# EL PASO COUNTY PLANNING AND COMMUNITY DEVELOPMENT DEPARTMENT

## GRADING AND EROSION CONTROL PLAN CHECKLIST ROLLING HILLS RANCH FILING 2

INDEX MAP  
N.T.S.

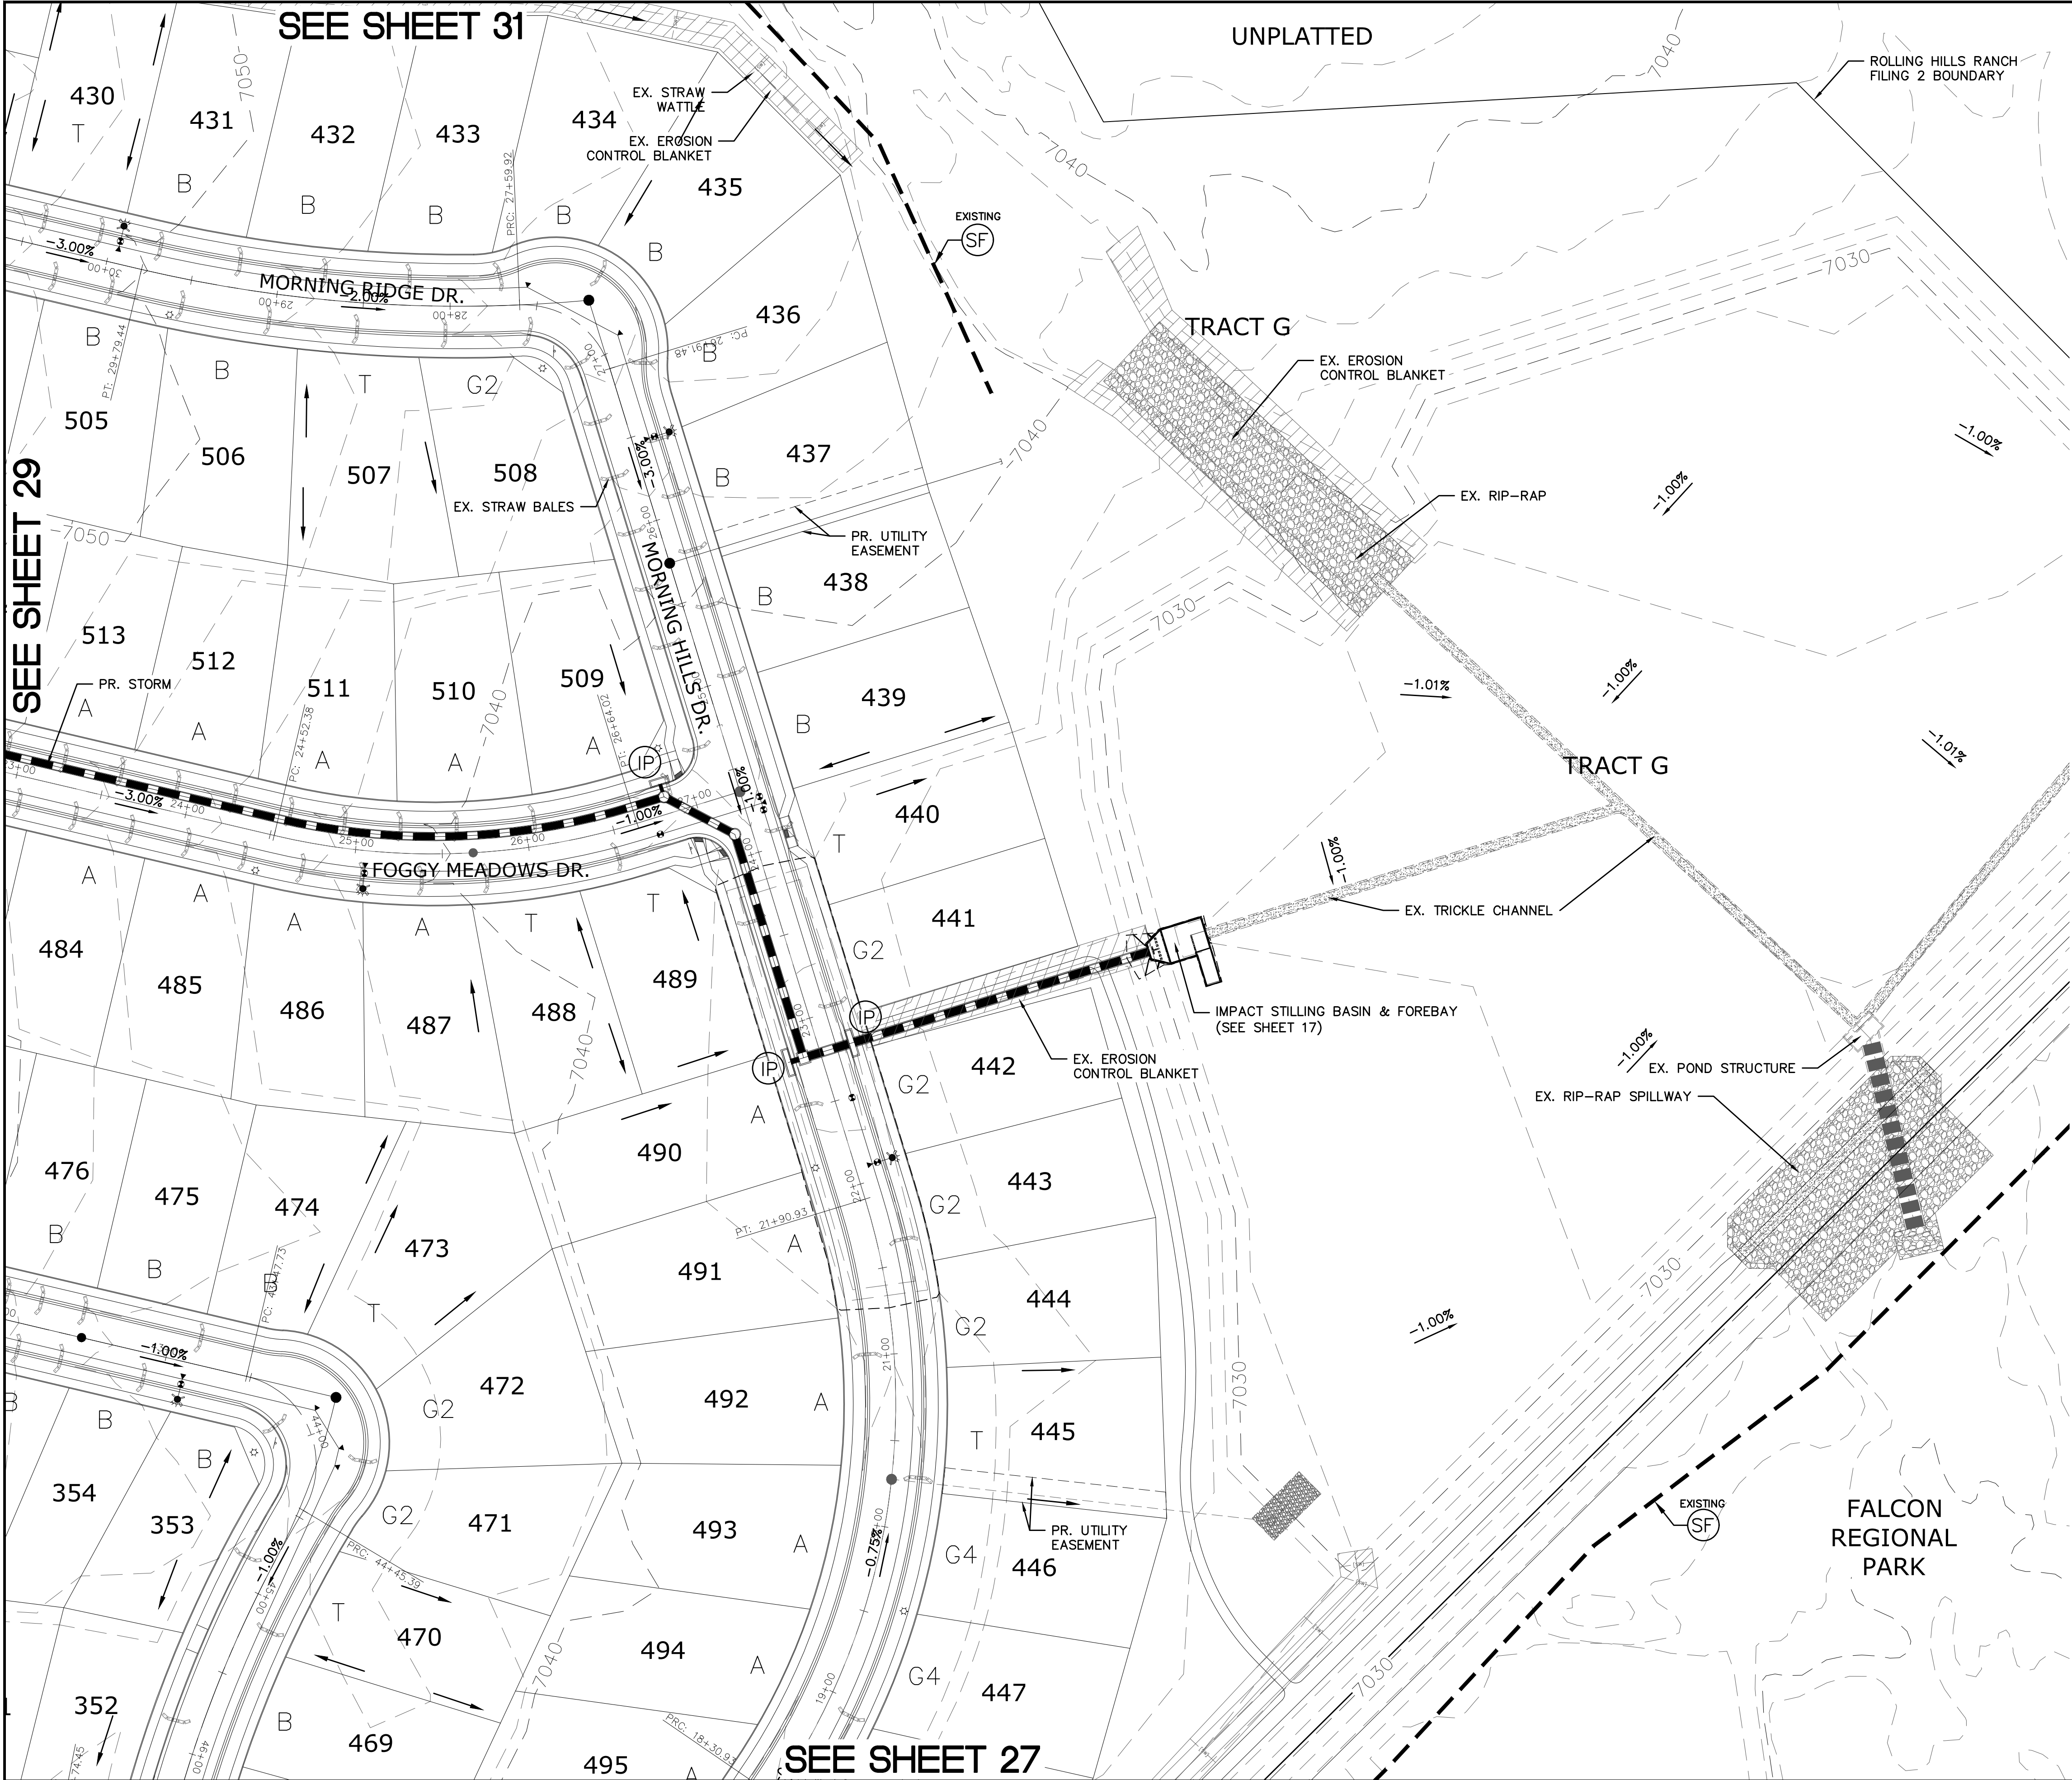
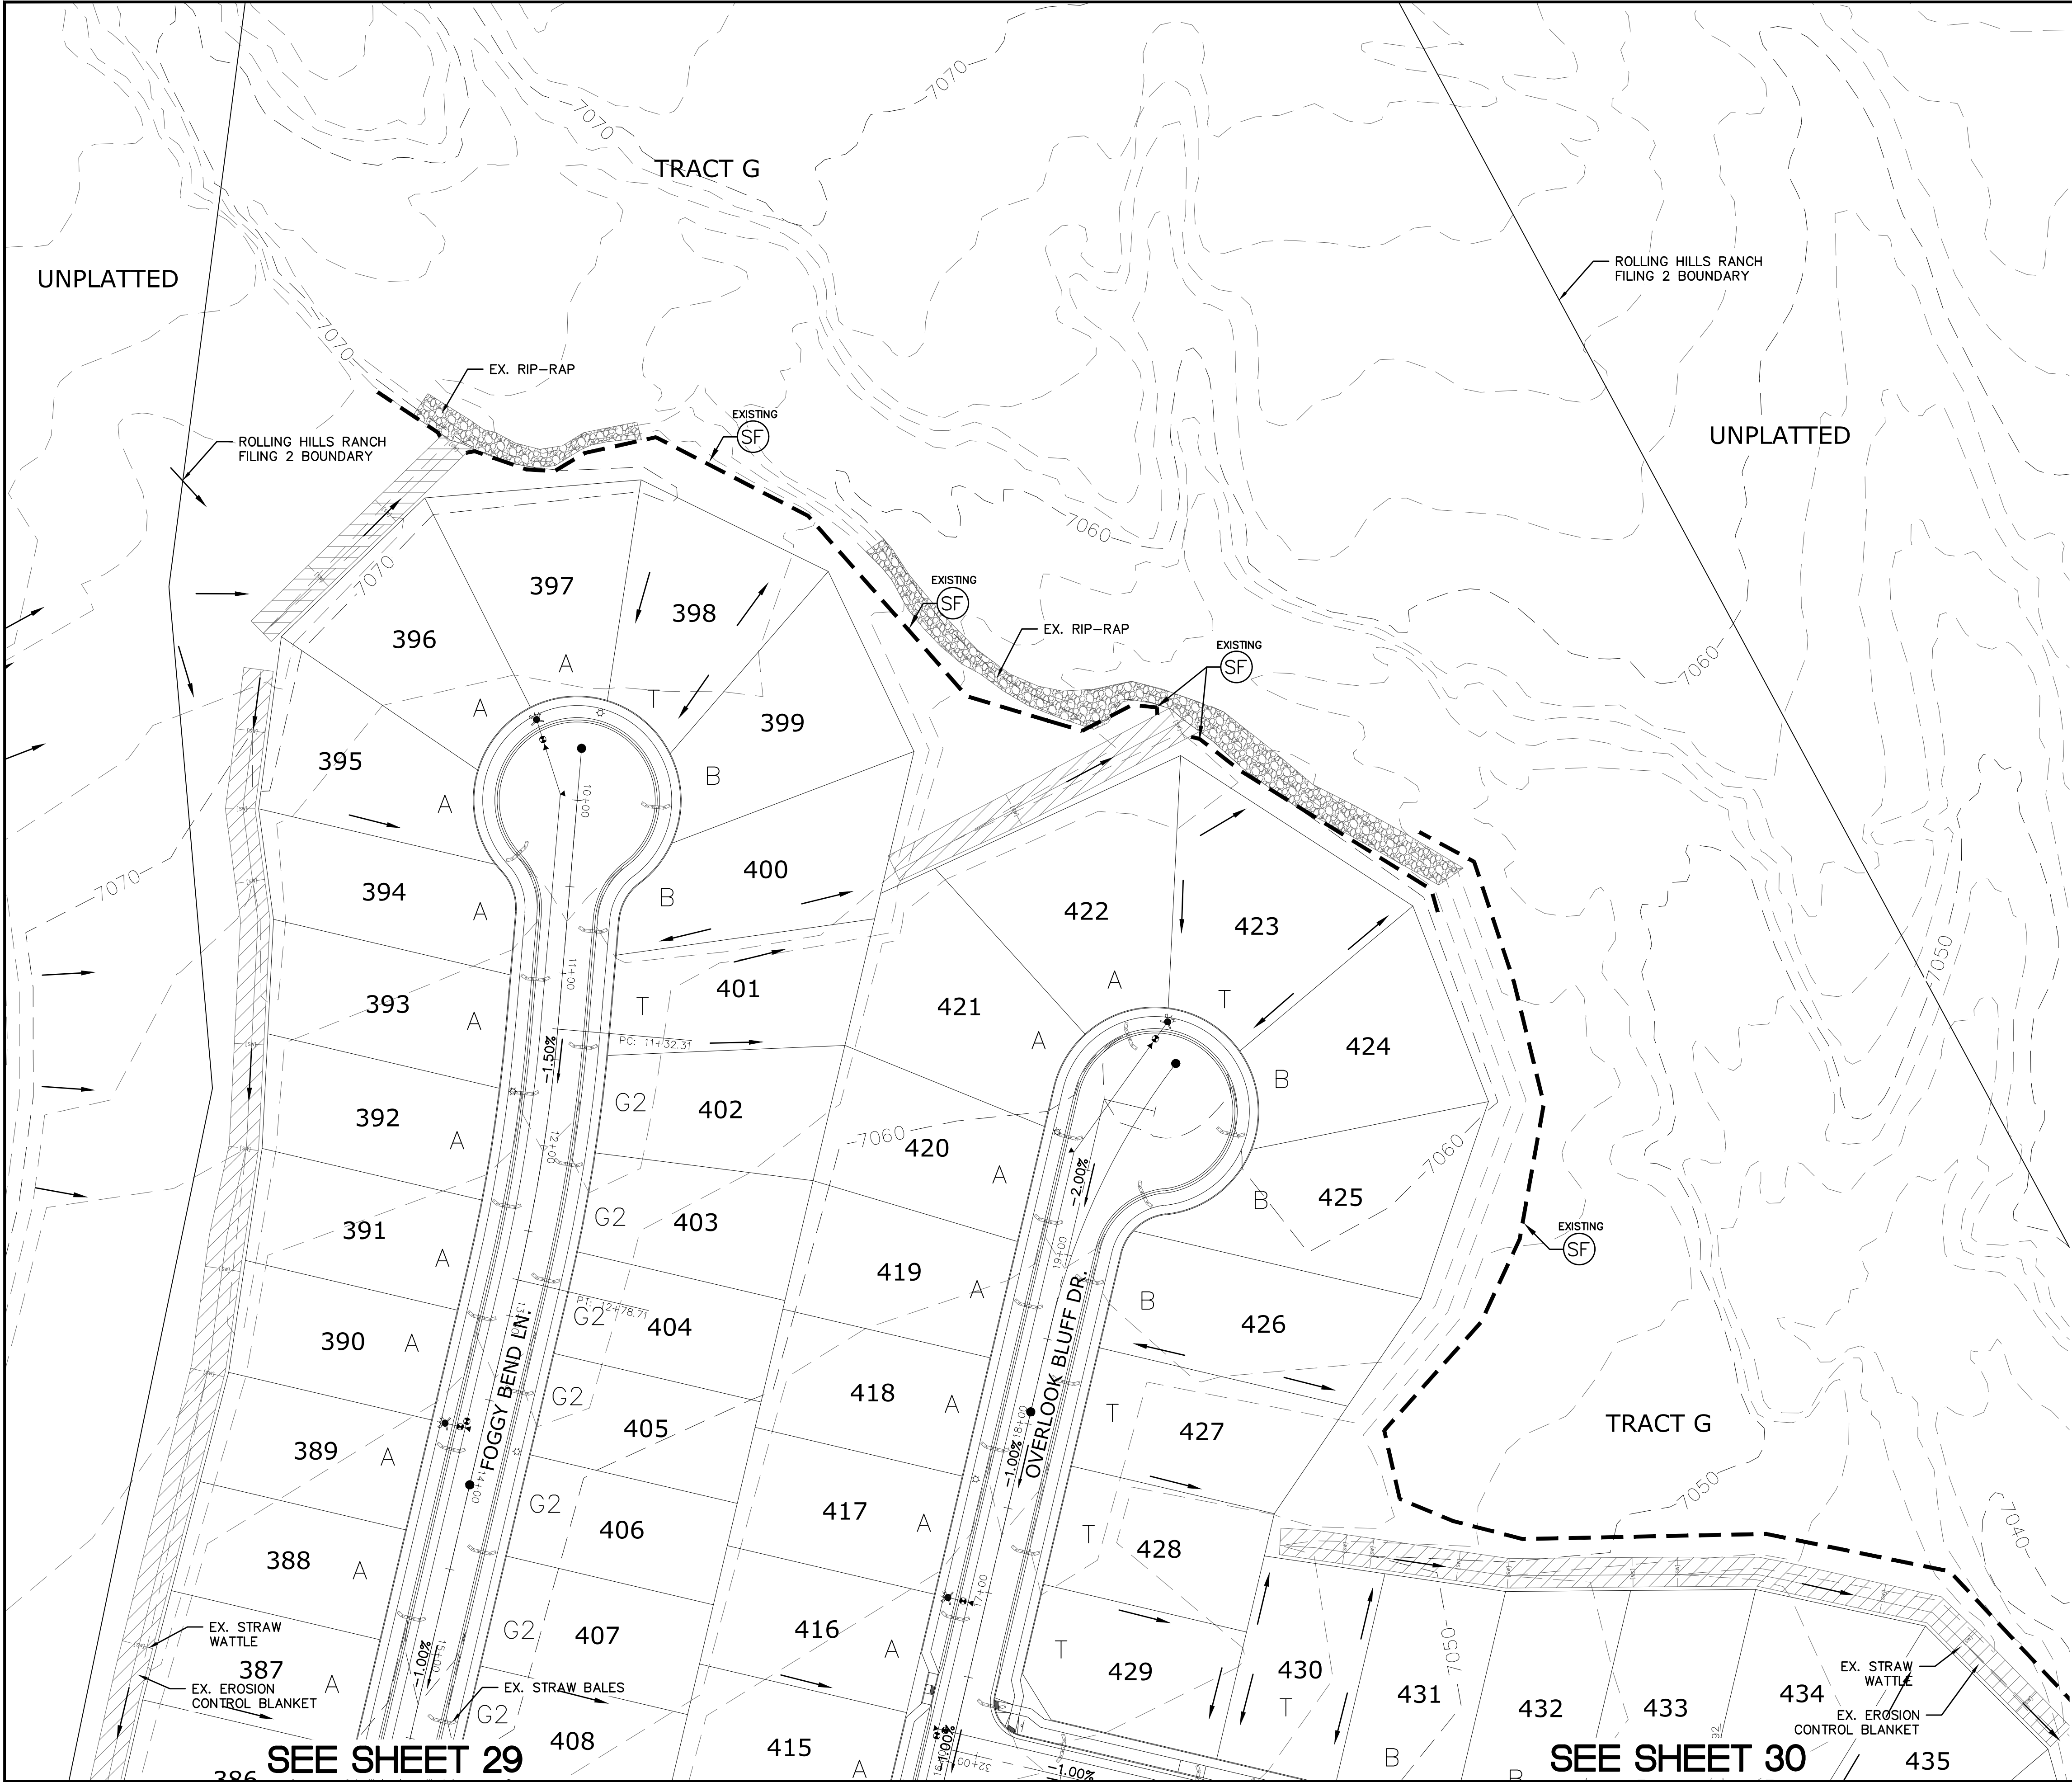
v	All proposed temporary construction control measures, structural and non-structural. Temporary construction control measures shall be identified by phase of implementation to include "initial," "interim," and "final" or shown on separate phased maps identifying each phase. Revised	✗	✗
w	Vehicle tracking provided at all construction entrances/exits. Construction fencing, barricades, and/or signage provided at access points not to be used for construction.	✗	✓
x	Temporary sediment ponds provided for disturbed drainage areas greater than 1 acre.	n/a	N/A
y	Dewatering operations to include locations of diversion, pump and discharge(s) as anticipated at time of design.	n/a	N/A
z	All proposed temporary construction control measure details. Custom or other jurisdiction's details used must meet or exceed EPC standards.	✗	✓
